**Application no:** H08-1006-11

**Description:** Erection of detached bungalow (outline application H08-0592-11)

**Location:** 59 High Street  
Gosberton  
Spalding  
Lincs  
PE11 4NJ  
PE11 4NJ

**Amendment:** Amended layout (dwg. no. 2035-01B)

1 Site Block Plan
1 : 200

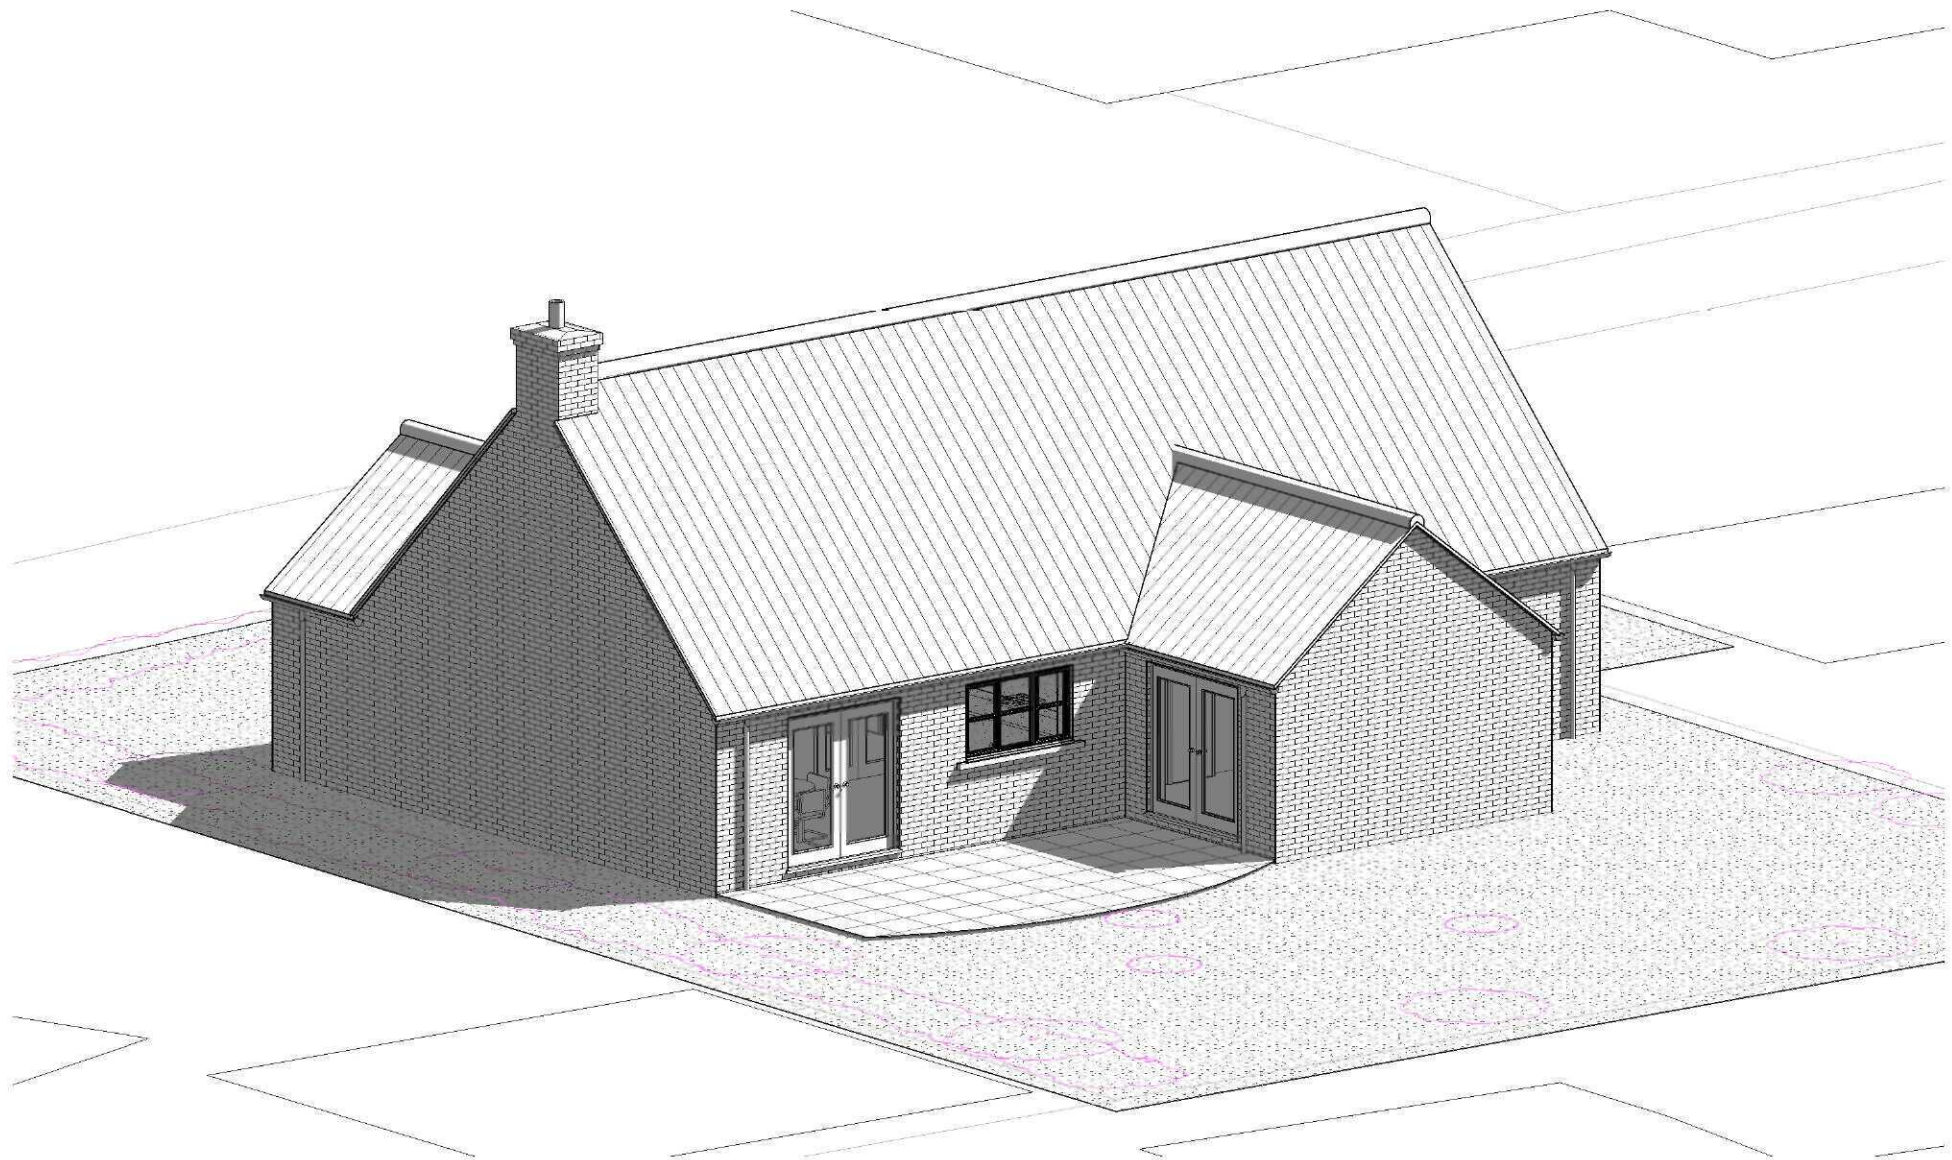
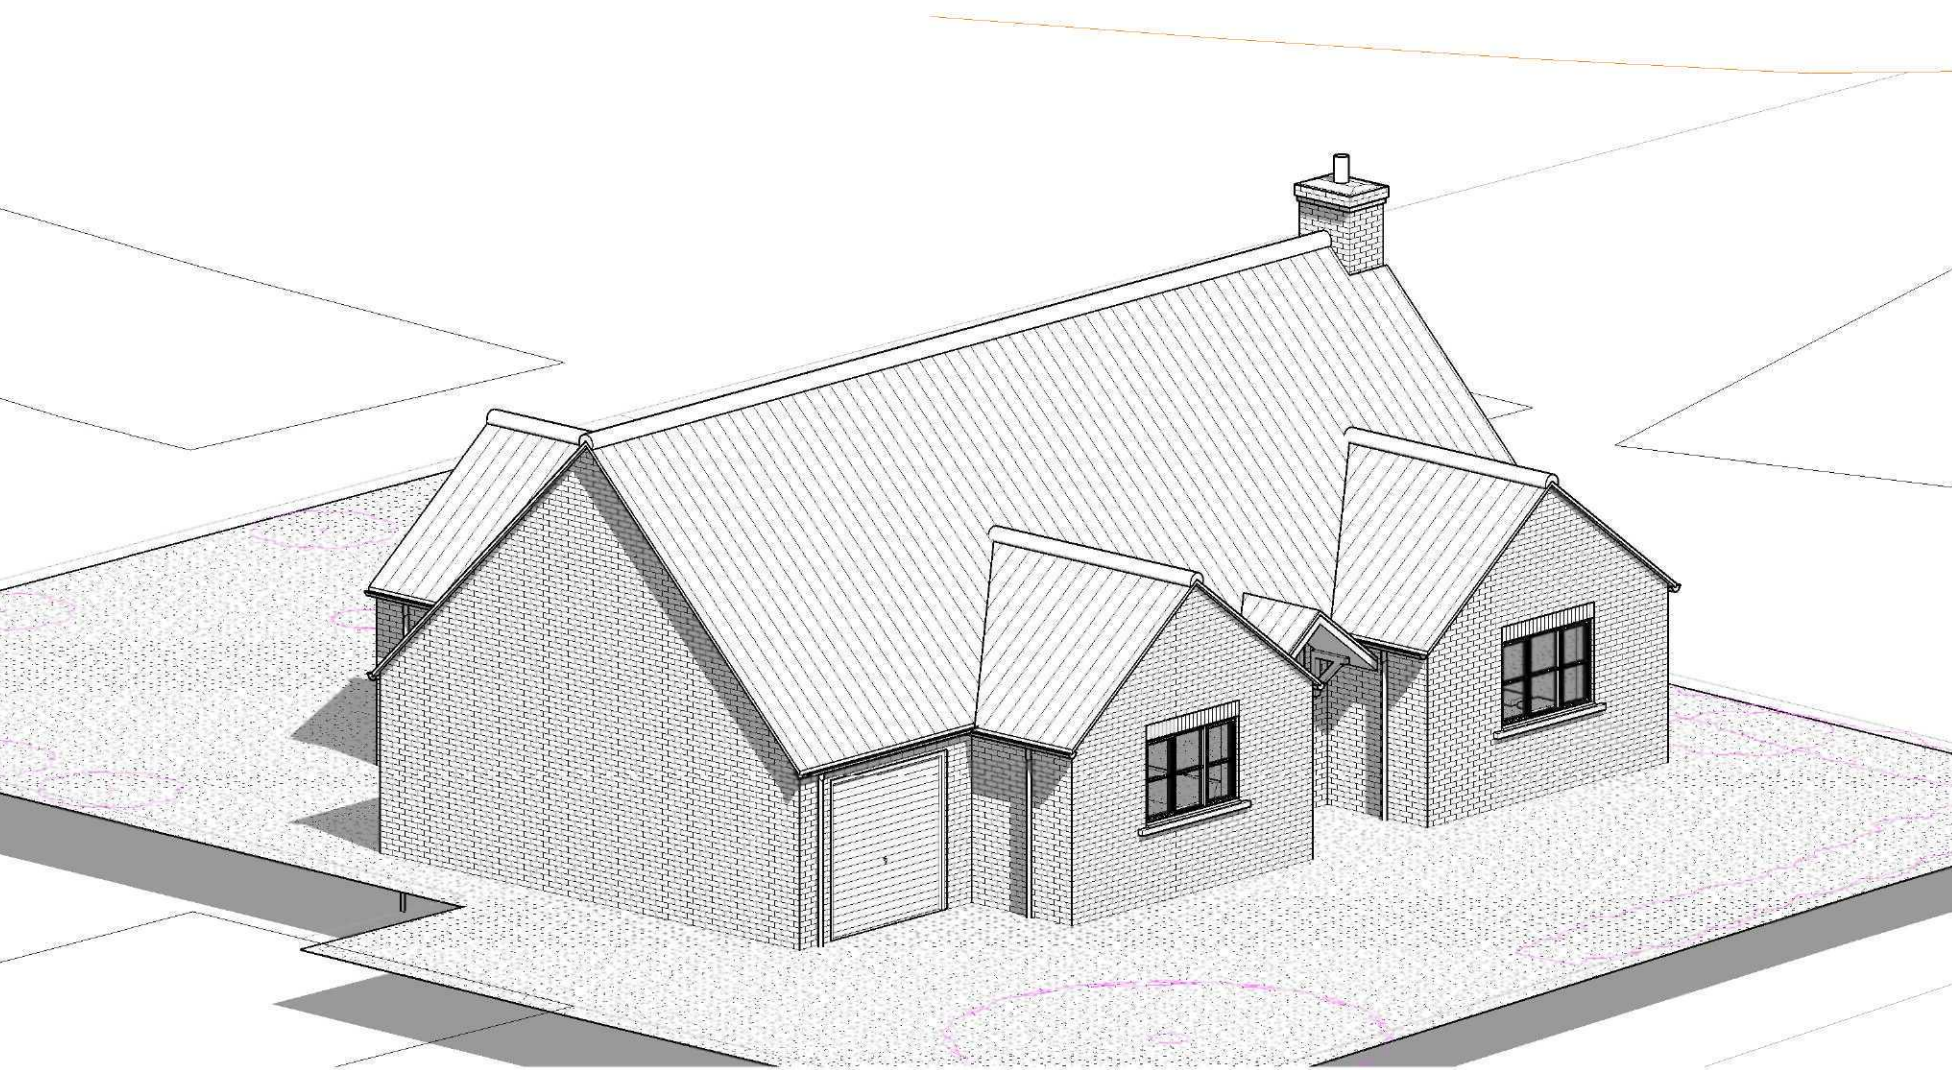
Please find attached revised site block plan showing tree annotations to comply with Condition 4. This work has been agreed with Diane Fairchild on site.

(iii). Standard Driveway construction only req'd due to the access being outside of the Root Protection Area i.e. 100mm deep compacted crushed limestone hardcore, 40mm blinded sharp sand with 65mm concrete block paving

(iv). The sewage and surface water discharge will be shared with number 59 and discharge into its existing system which in turn discharges into the mains sewer system within high street

(v) The existing access road and site ground levels are set at a level of 0.000 as shown on design plans and these are to remain. The proposed floor level is to be set at 0.150 (150mm above centre of access road and surrounding grd levels)

2 Front Elevation
1 : 100

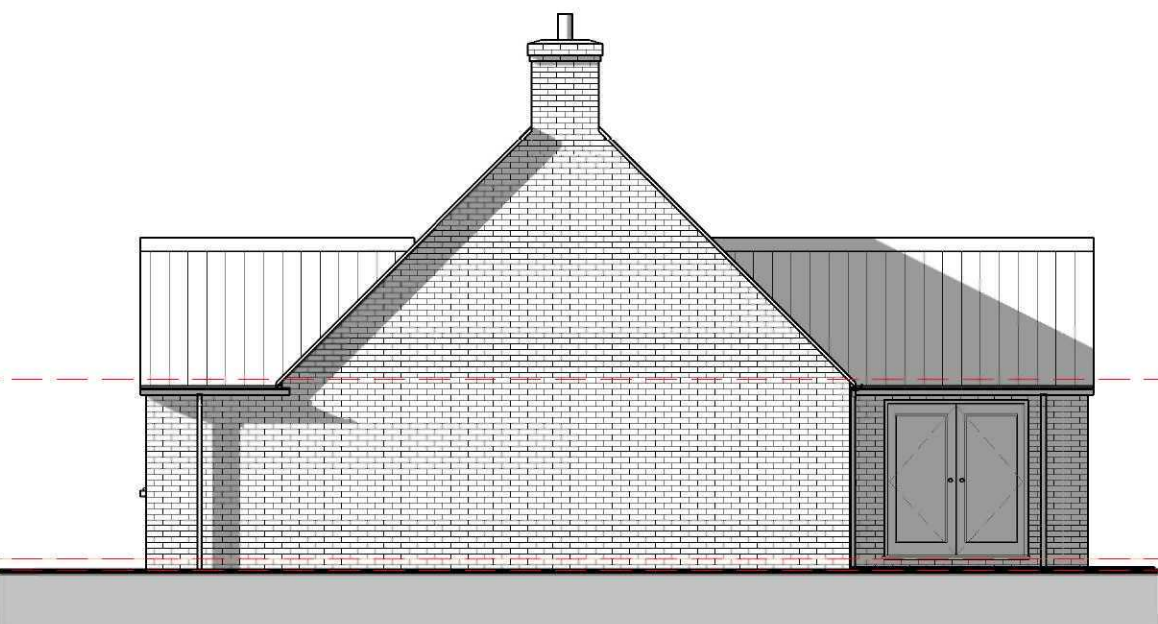
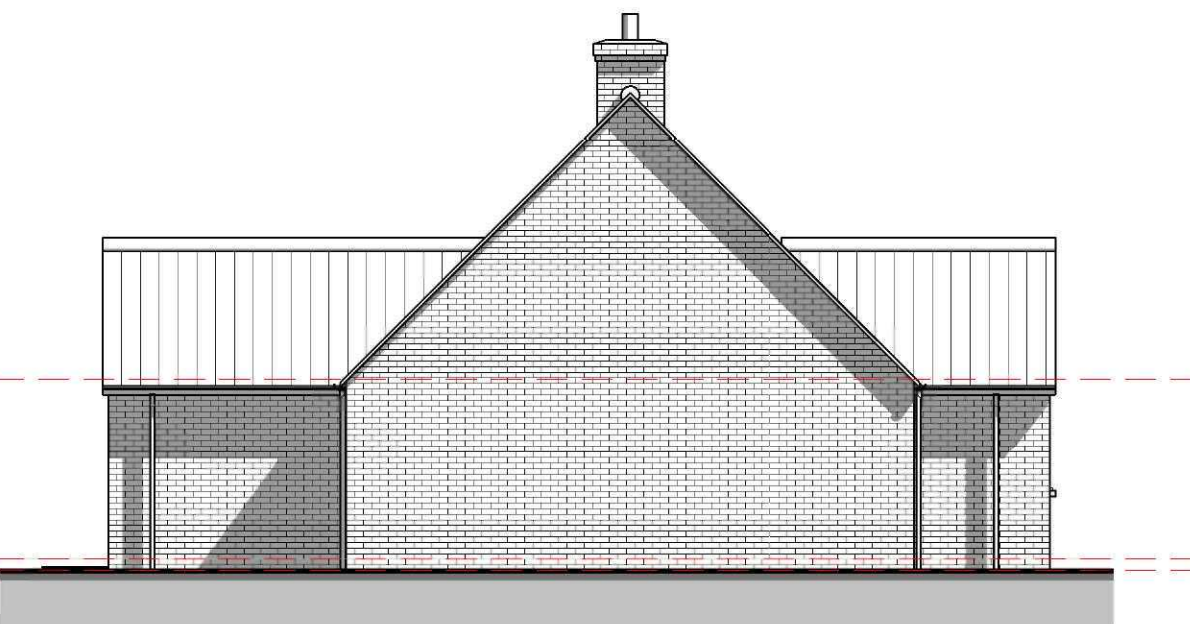
I've just spoken with the applicants and they have agreed with a certain amount of persuasion to lower the roof to 40 deg.

Thanks for your email. I've discussed the matter with Richard and we are prepared to accept this as a compromise.
